EPC STORMWATER REVIEW COMMENTS ARE SHOWN IN ORANGE BOXES WITH BLACK TEXT

# PREDEVELOPEMENT GRADING FOR ROLLING HILLS RANCH NORTH AT MERIDIAN RANCH

TECH CONTRACTORS 11886 STAPLETON DRIVE FALCON, CO 80831 TELEPHONE: 719.495.7444 FAX: 719.495.2457		MERIDIAN RANCH	
PREDEVELOPMENT GRADING ROLLING HILLS RANCH NORTH ROUGH GRADING AND EROSION CONTROL PLAN COVER SHEET			
Drawn by	LOG	Checked by	TAK
Scale	AS SHOWN	Date	MARCH 2022
1 of 23		Revise to EGP222

**IMPACT STILLING BASIN & FOREBAY**  
CROSS SECTION E-E'  
NTS

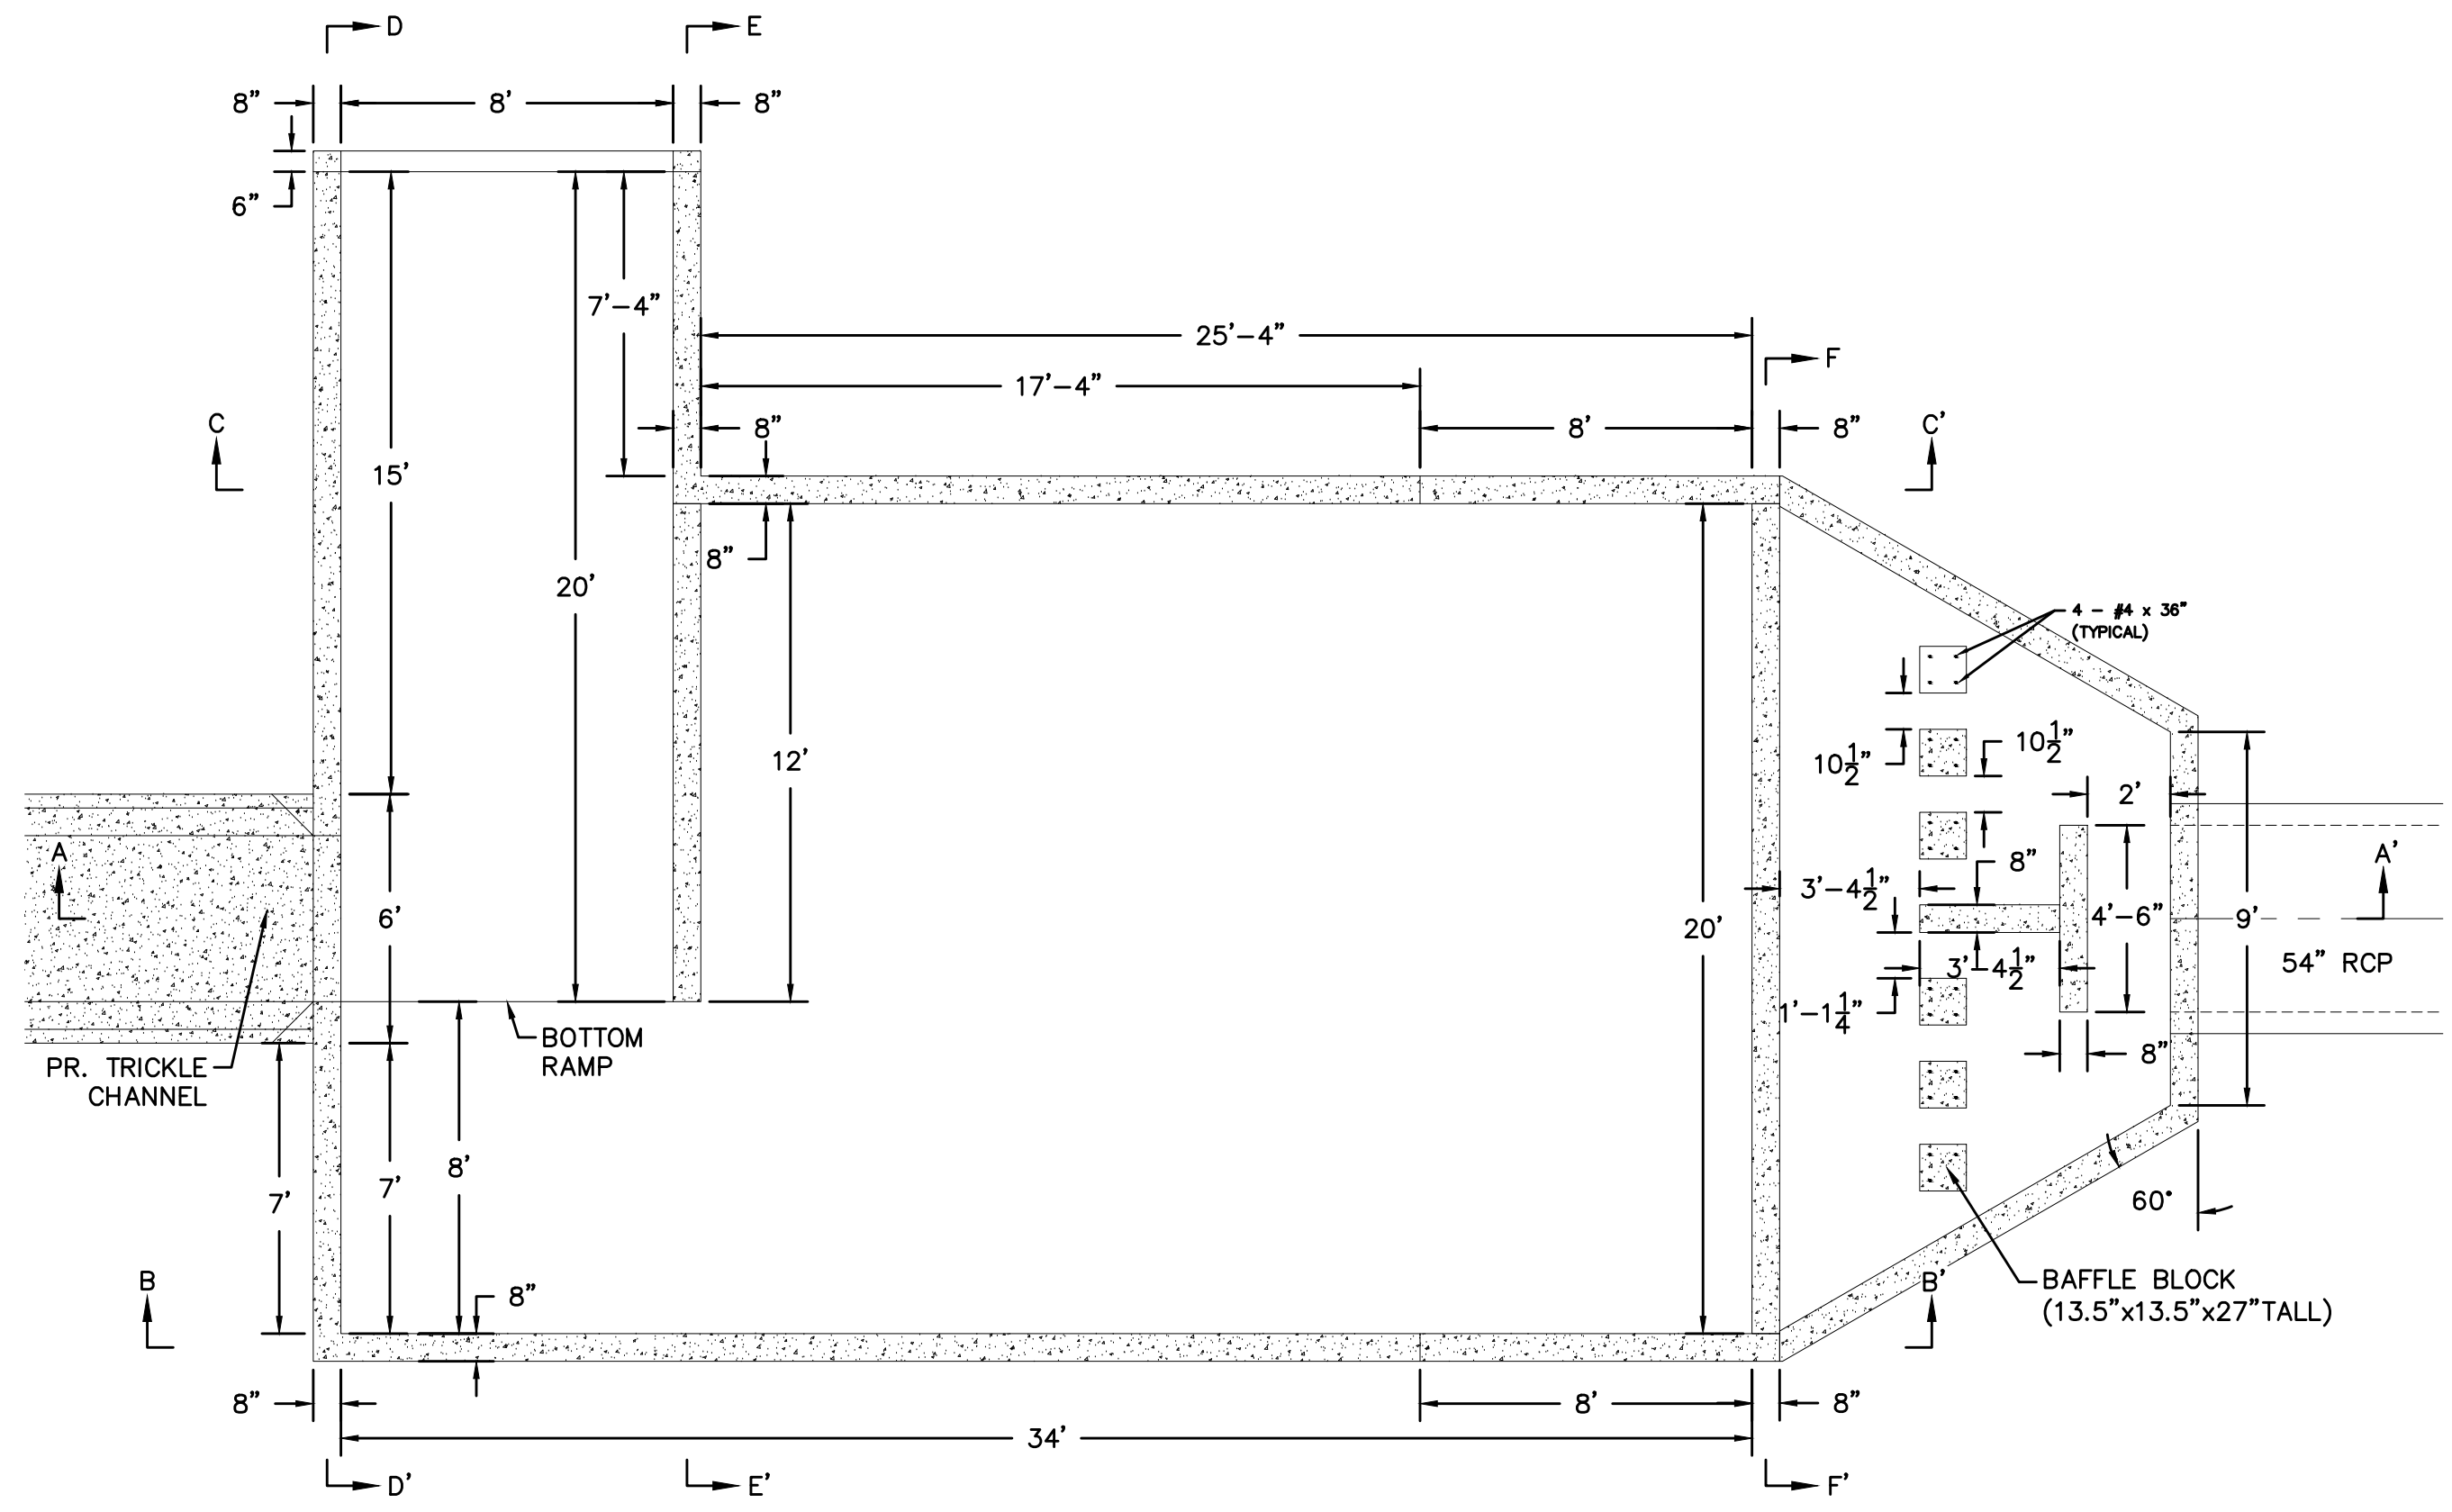
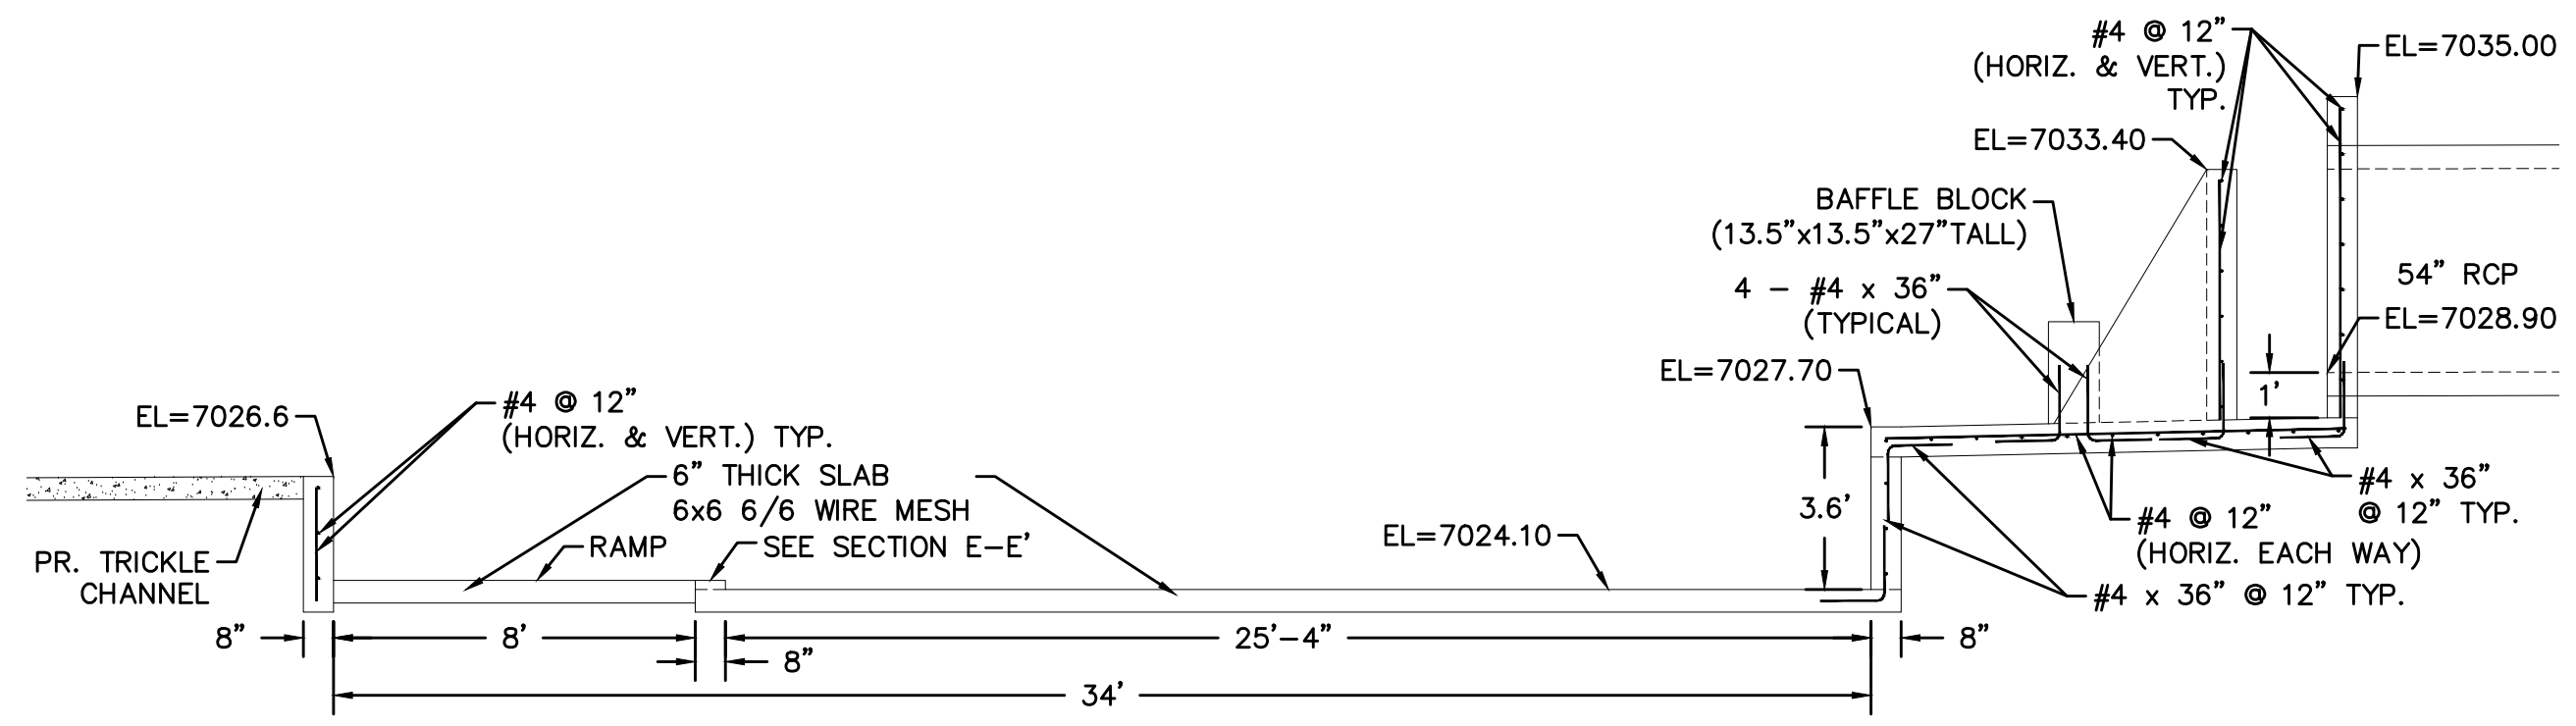
Please explain in the narrative why a 54" pipe and impact stilling basin is used. Staff assumes this is designed based on the full development of the subdivision and will remain after the temporary sediment pond is removed.
